PAVEMENT DESIGN REPORT

**Village Center
Village at Lorson Ranch, Filing No. 1
El Paso County, Colorado**

JOB NO. 197432

**April 28, 2025
Revised: July 9, 2025**

RECOMMENDED
PAVEMENT
SECTIONS

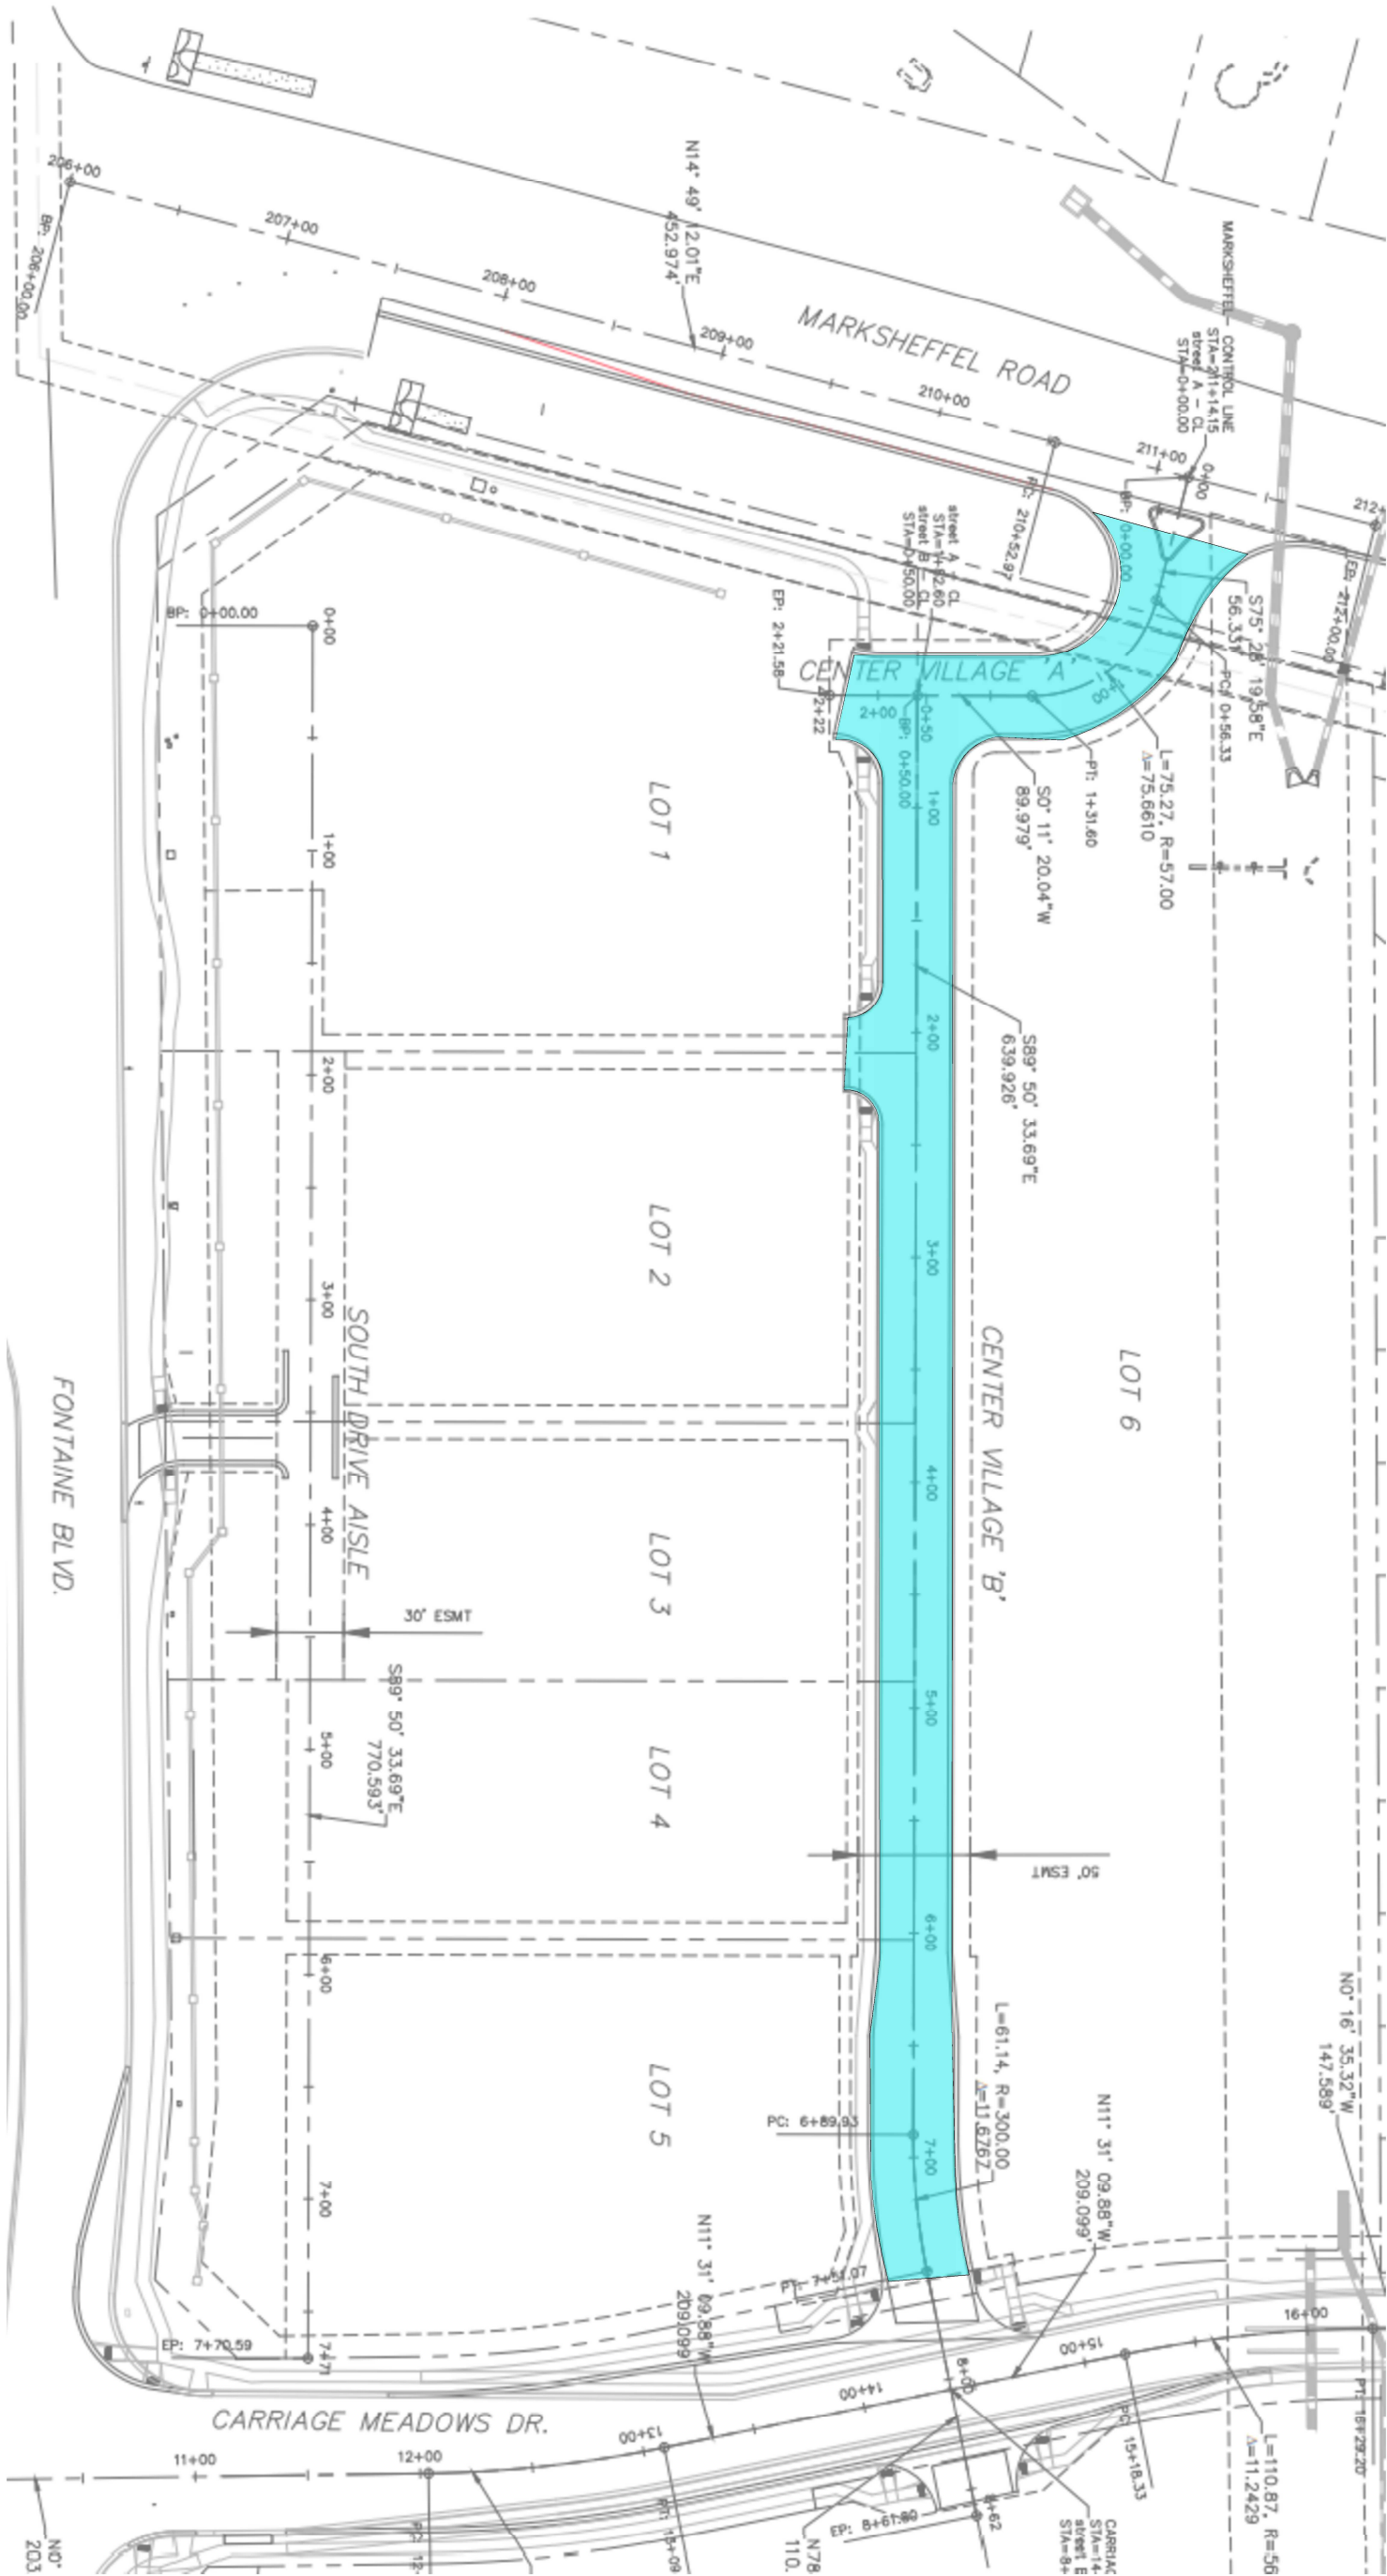
3 inches of HMA over 10 inches of ABC > a ratio of 2.5 - use 4.75 inches of HMA

Calculated SN: $(4.75 \times 0.44) + (11.5 \times 0.12) = 3.47 \geq 3.42 \rightarrow \text{OK}$

The use of CTS requires a deviation request. Deviation is from ECM D.4.1.F. The deviation request shall address the eight points included in the Use of CTS for Paving Season document.
